From: Amanda Scholes on behalf of Planning.Responses
Sent: 12 January 2022 07:49
To: Planning Scanning
Subject: FW: Planning Re-Consultation on: A/255/21/DOC

Engineers Comments Regarding Condition 5

Application No: A/255/21/DOC
Registered: 1st December 2021
Site Address: Merry England Nurseries Dappers Lane Angmering BN16 4EU
Grid Reference: 507336 105060
Category: Discharge of Condi
Description of Works: Approval of details reserved by condition imposed under A/142/16/OUT relating to conditions 5-as built drawings of the implemented SuDS scheme together with a completion report, 8-updated copy of the management manual or confirm in writing no changes are required to the manual & 23-verification report demonstrating completion of the works set out in the approved remediation strategy.

<p>cgs civils Consulting Civil Engineers</p>					
CLIENT		GD GROUP			
ARCHITECT		CITYZEN			
JOB TITLE		MERRY ENGLAND ANGMERING			
DRAWING TITLE		DRAINAGE LAYOUT			
DRAWN	LH	ENGINEER	CS	CHECKED	CS
DATE	SEPT 2019		1:200		
DRAWING No.	C1249	STATUS	C	DRAWING No.	100
REV	A

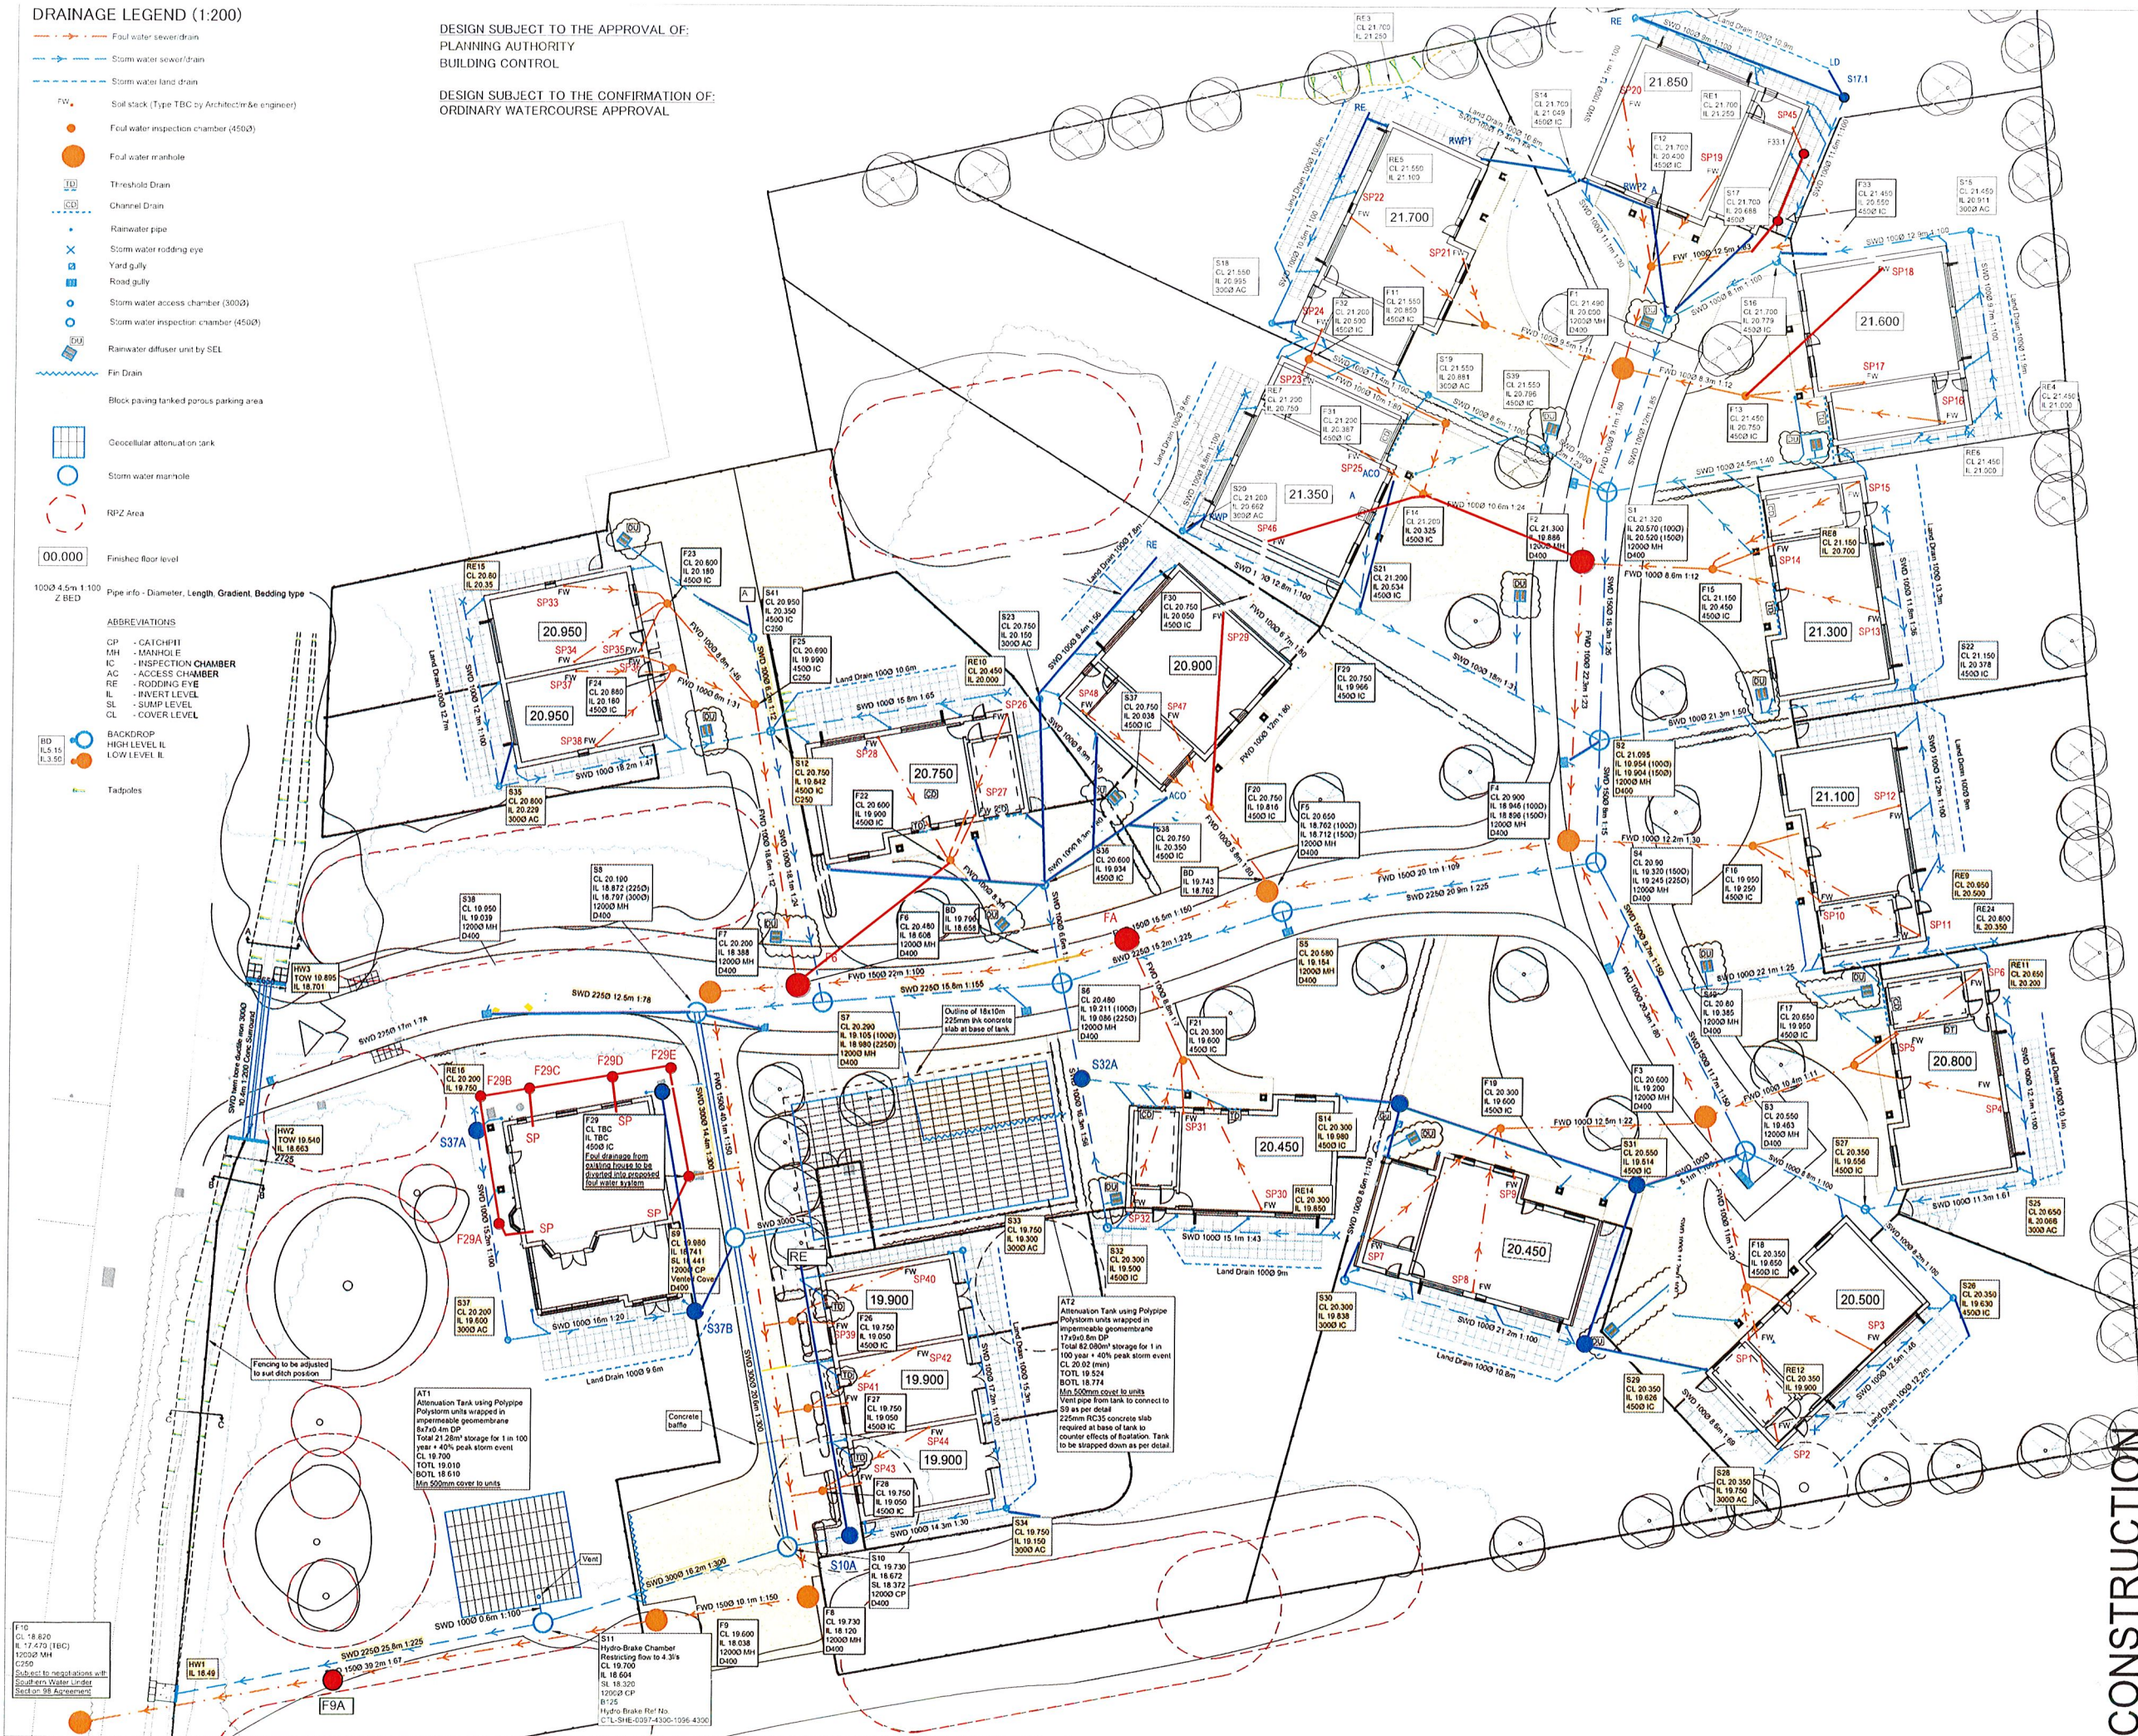
The invoice for the attenuation tanks states that 196 Polystorm PSM1 crates were ordered. We believe that the design requires over 700 crates.

The photos supplied to evidence the construction of AT2 clearly show that this attenuation tank has been constructed to only one crate depth, despite the design specifying two crates depth. The photo also appears to show Terram surround the crates, but no impermeable tanking membrane.

Please also clearly detail if each of the defects picked up by the independent engineer have been rectified. Five photos have been supplied, but more than 5 defects were identified.

We do not recommend discharge of condition 5 at this time as the evidence supplied raises significant questions about the construction. Please supply evidence that construction has occurred in accordance with the design. It may be that some areas need to be reconstructed.
